Our ref: SE1612-ISS-XX-XX-CO-C-0002

RE: Pound Place – Drainage Submission for 64Bed Scheme.

Please find attached our revised submission to discharge Condition 3 of the planning application for the above noted site.

I write in response to your comments dated 30/06/20 listing 12 points to reconcile and below is our response in order of your list:

CONTINUED ON DRG PP-ISS-XX-XX-DR-C-3501

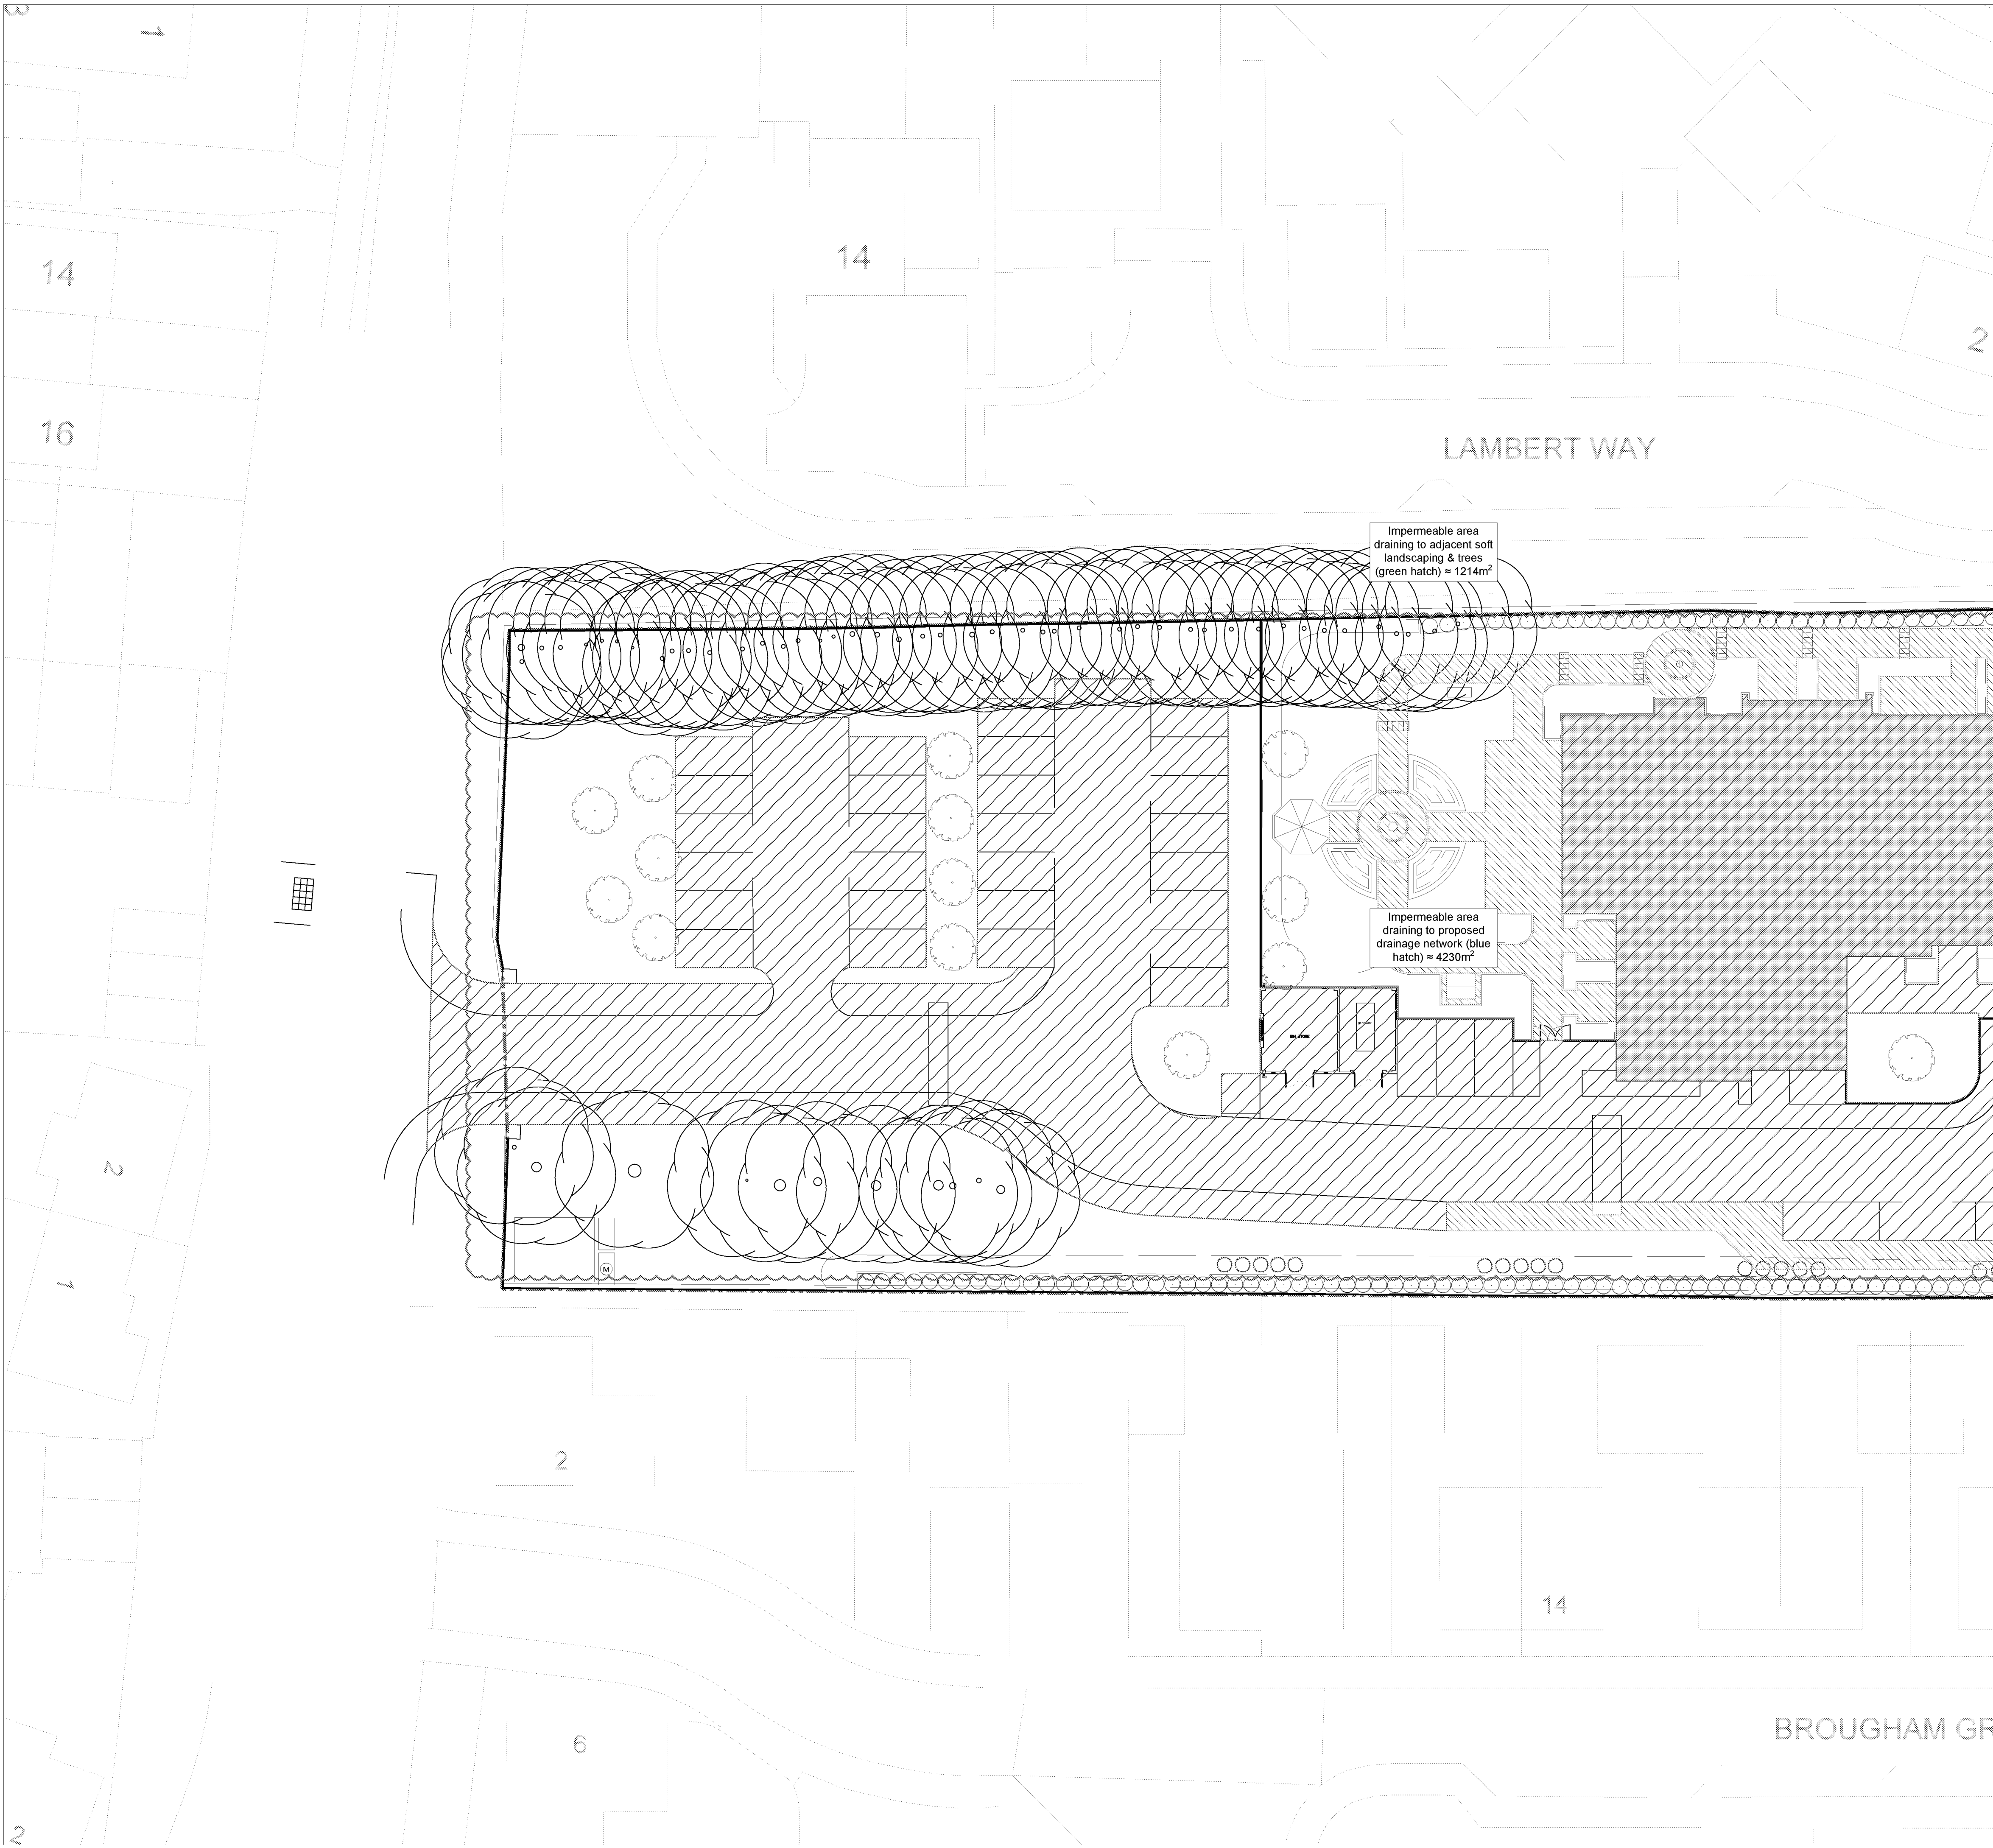
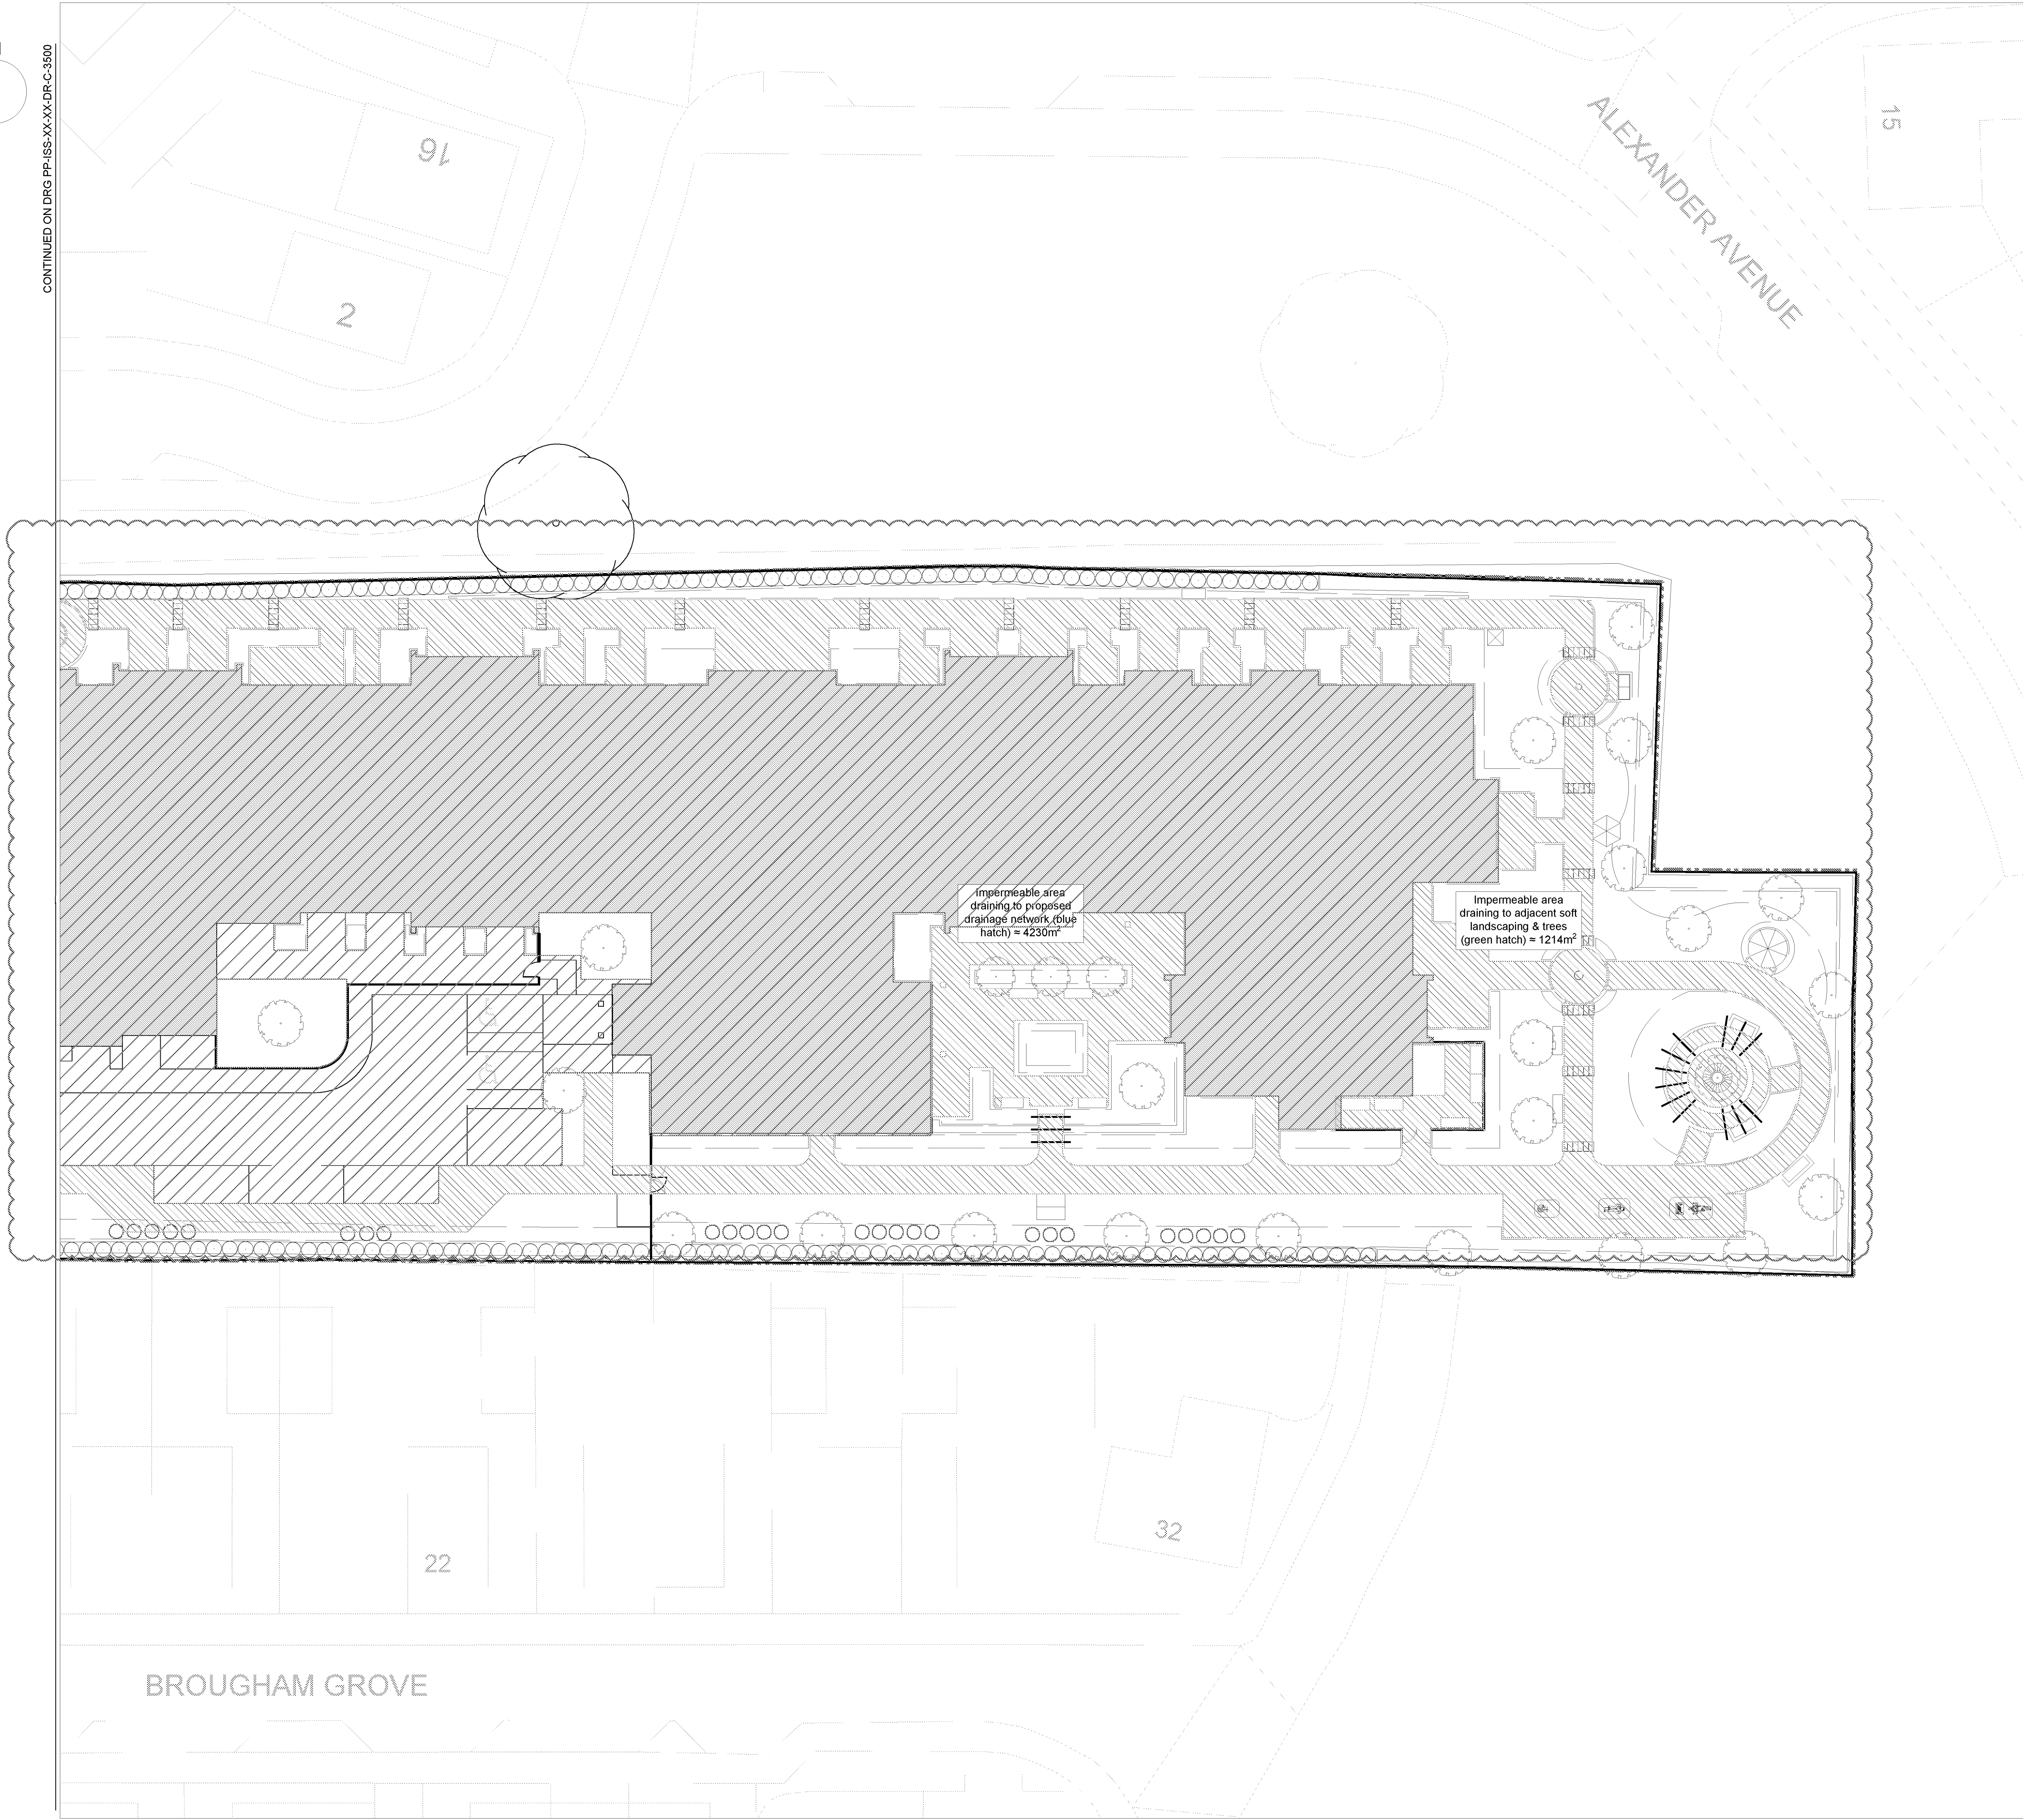
1. Ground and formation levels have been added for all permeable paving areas (dwg PP-ISS-XX-XX-DR-C-3011 to PP-ISS-XX-XX-DR-C-3013)
2. Revised catchment plan provided (dwg PP-ISS-XX-XX-DR-C-3500 to PP-ISS-XX-XX-DR-C-3501)
